Our ref: DOC22/1017183
Your ref: SSD-9679

Hills of Gold Wind Farm – Amended Project – November 2022

Hills of Gold Wind Farm – Amended Project

Hills of Gold Wind Farm – Residual matters and Amended Project

F3-1

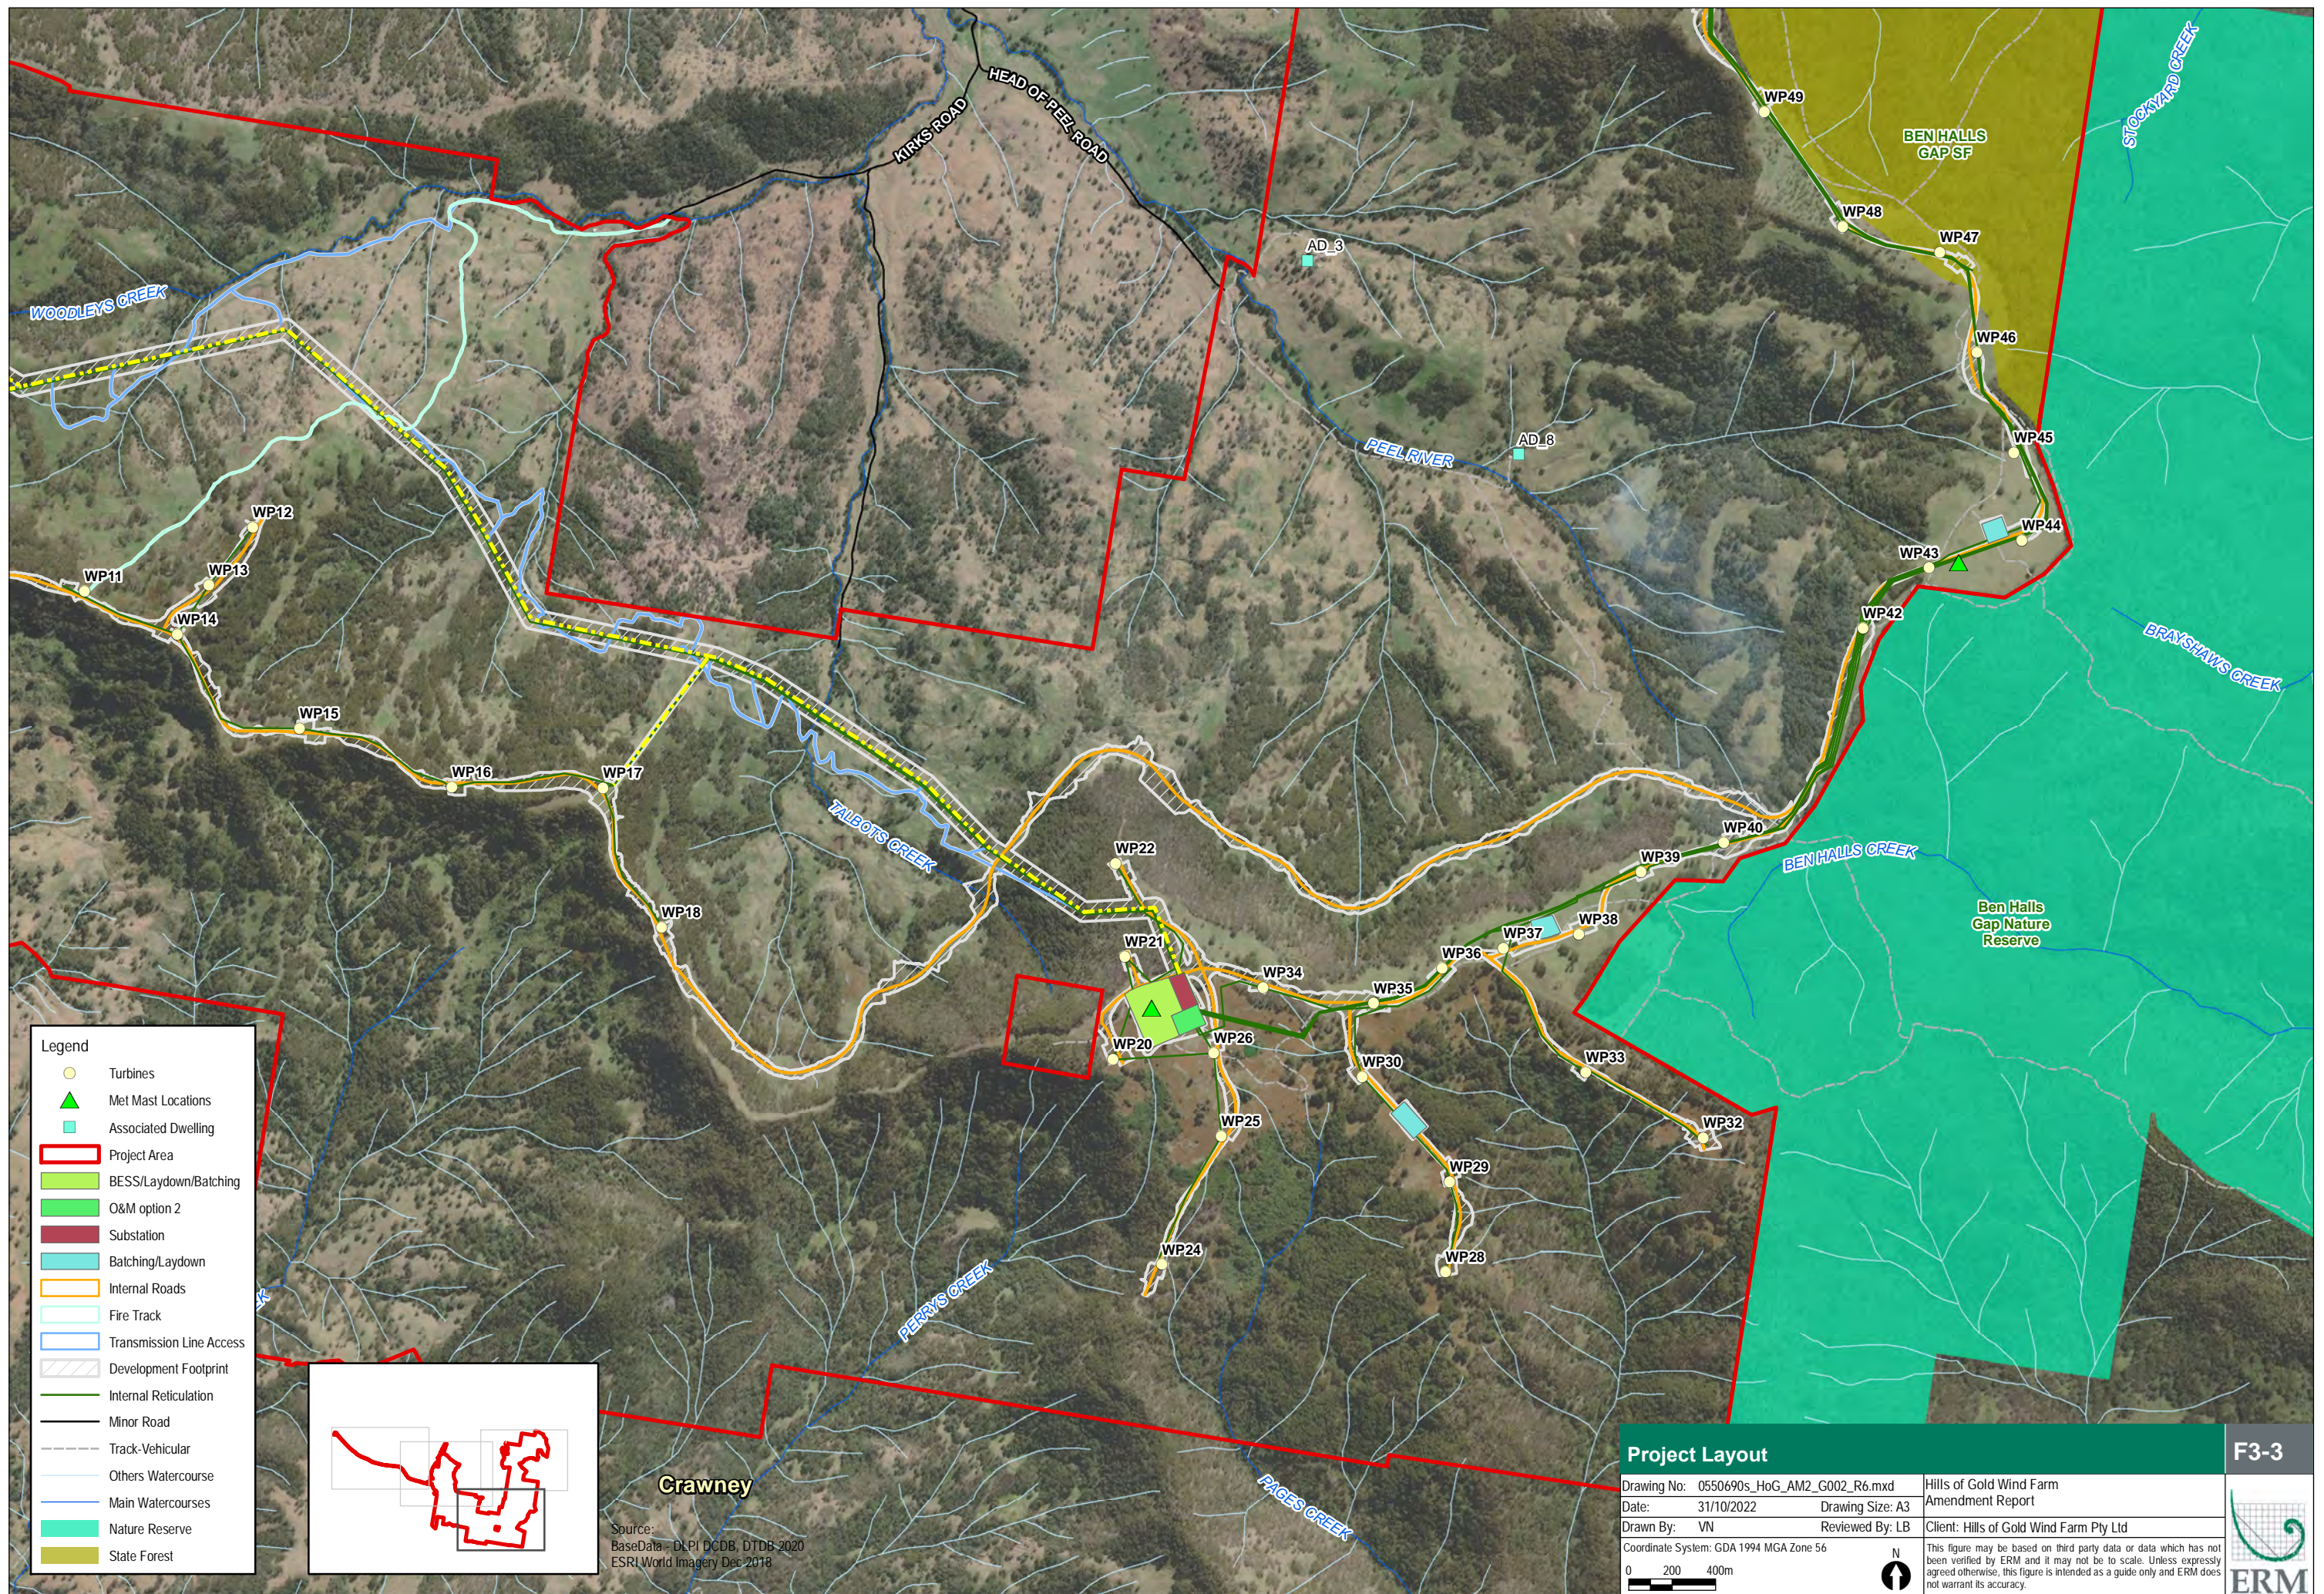
There are several turbines that BCS regards as potentiation candidates for deletion from the project. For example, turbines WP24 and WP28 are placed in PCT 1194, a Threatened Ecological Community (TEC). It is stated in Table 54 that further avoidance of biodiversity impacts is not possible for these turbines, due to the turbines being located within a highly vegetated area. The deletion of these turbines from the project will achieve further avoidance of a TEC as well as reduce the potential of blade strike for microbats.

- 2.2 Where moderate risk turbines are unrelocatable and proposed to be retained detailed justification is required. In the absence of detailed justification, the relative impact of each turbine should be considered and turbines resulting in the highest biodiversity impact should be deleted.

F3-20

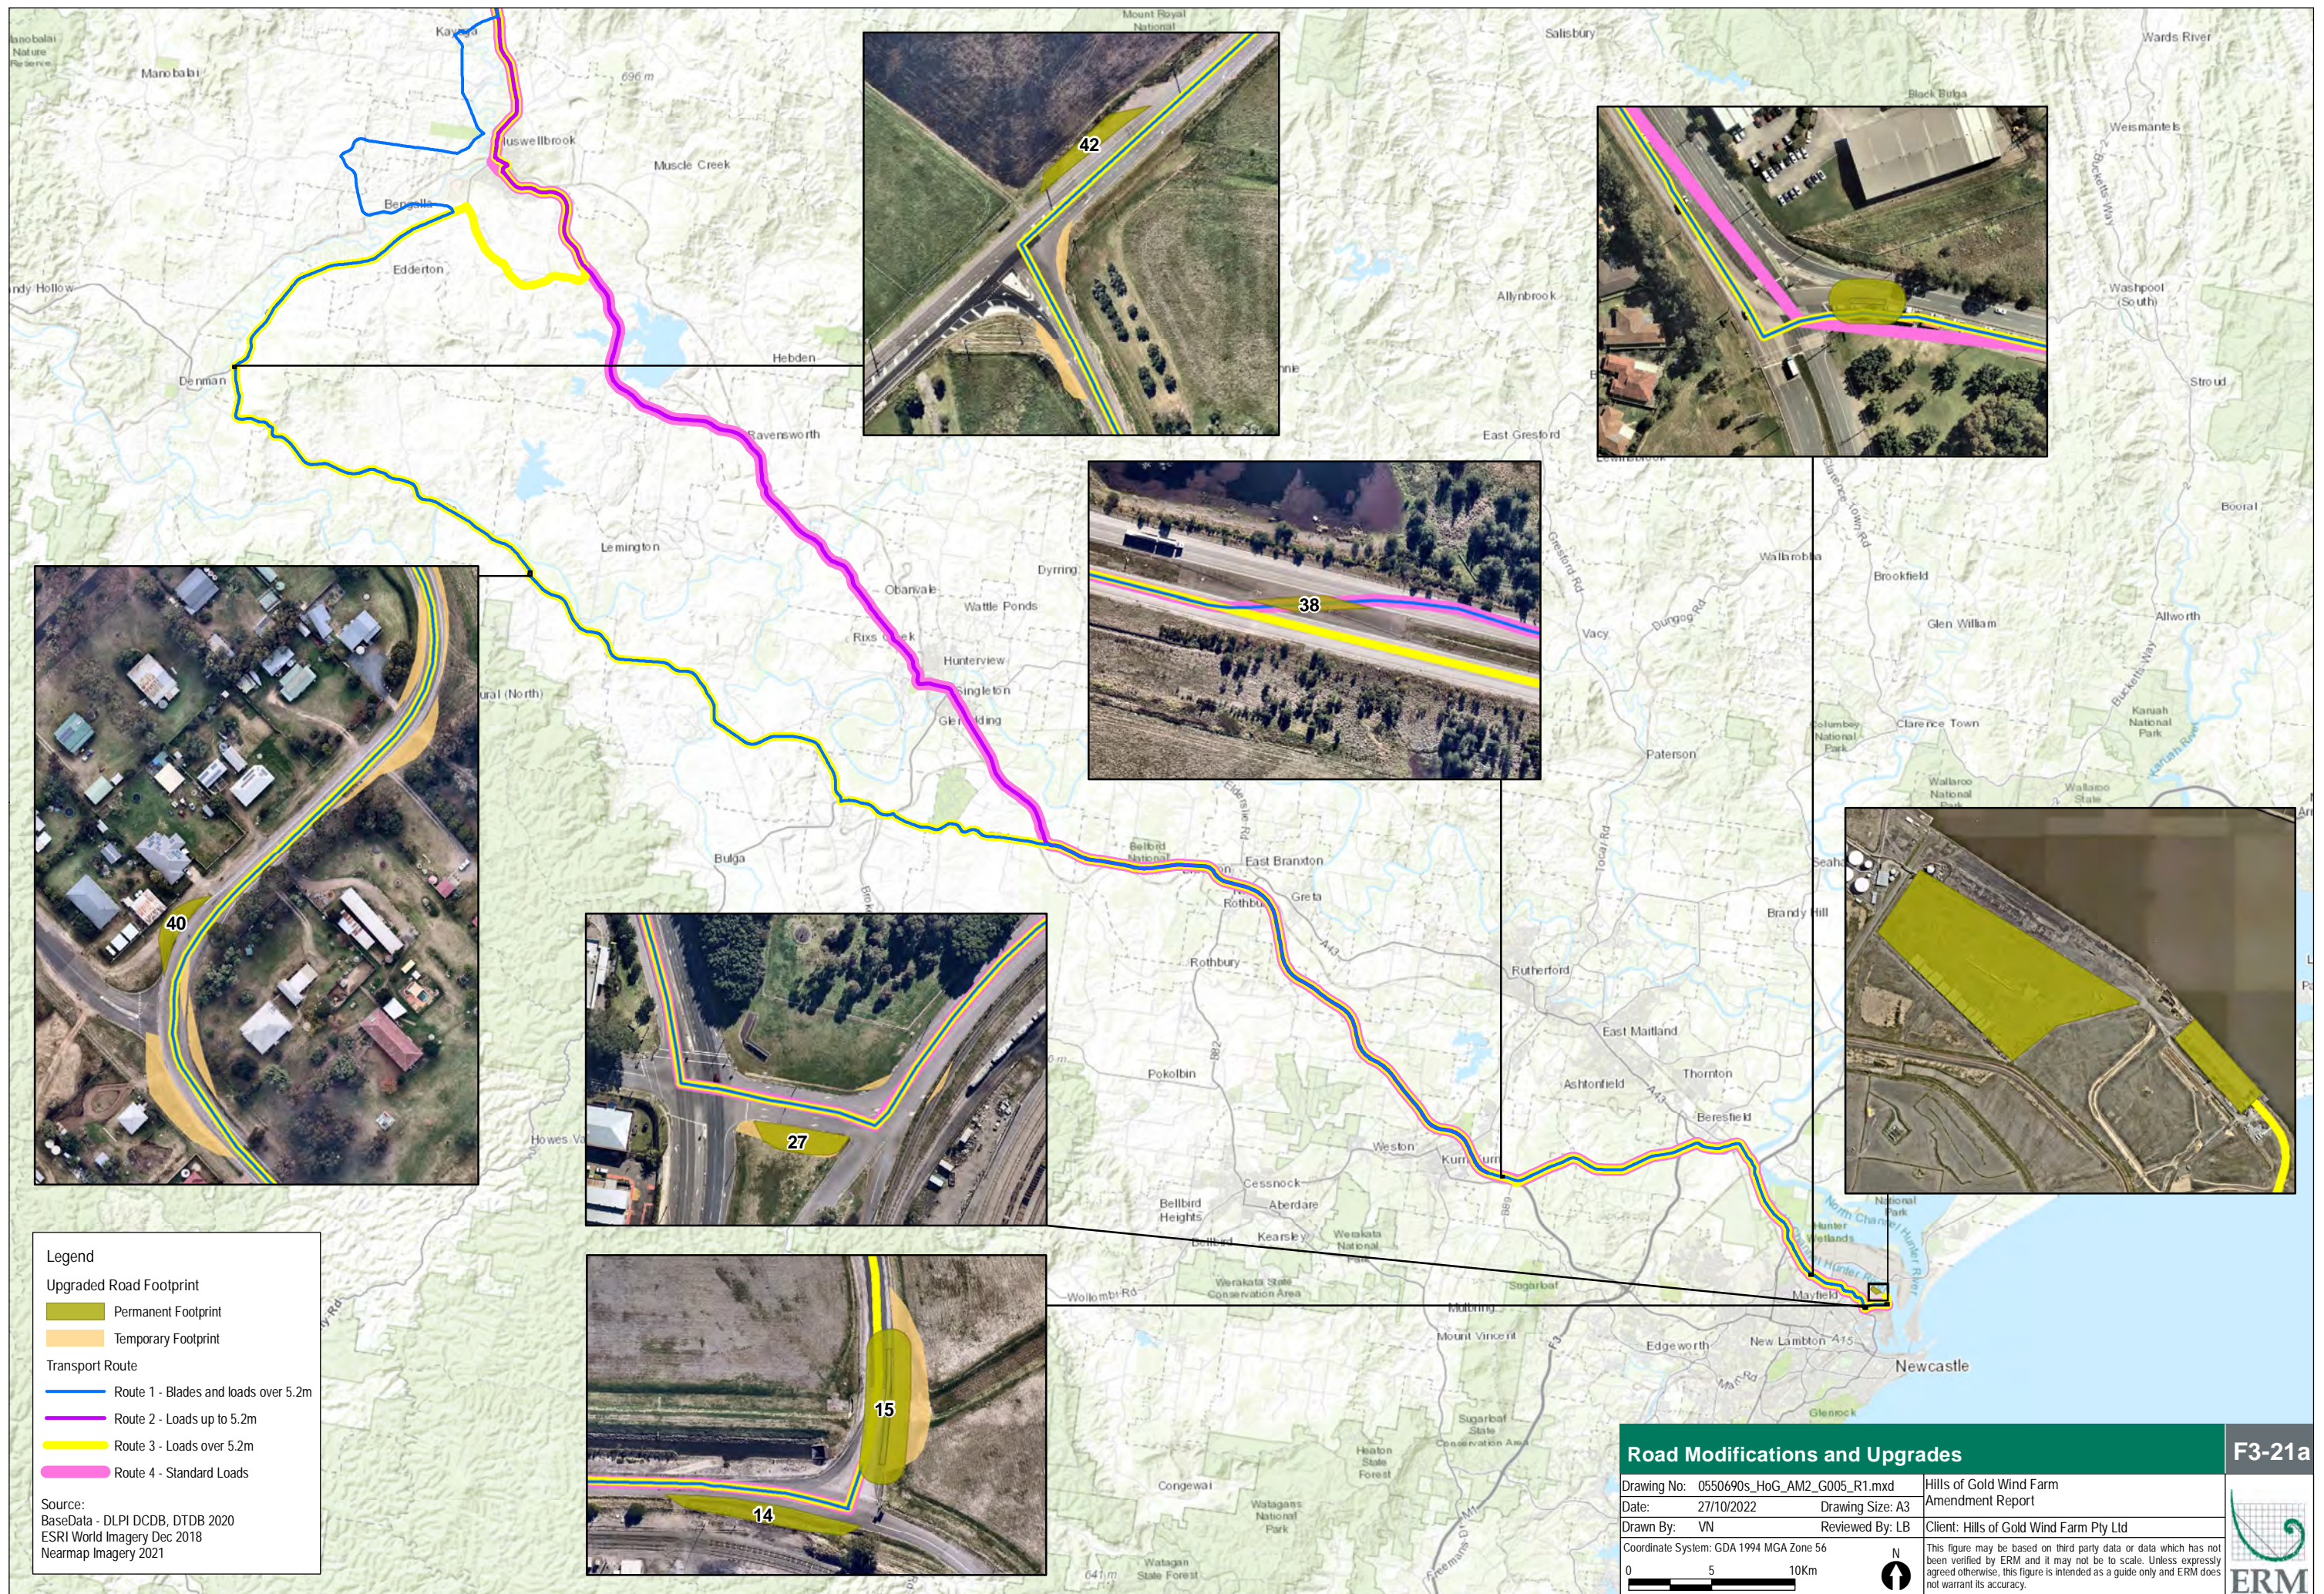
Table 59 of the BDAR provides a summary of the primary biodiversity considerations of the three options without providing any indication of additional constraints, or the proponents preference, relating to the three options. As such, there is insufficient information for BCS to develop an informed opinion on the merits of the proposed options.

6.1 The proponent should determine an access option for the subject site based on the option which would present the least relative impact to biodiversity values.
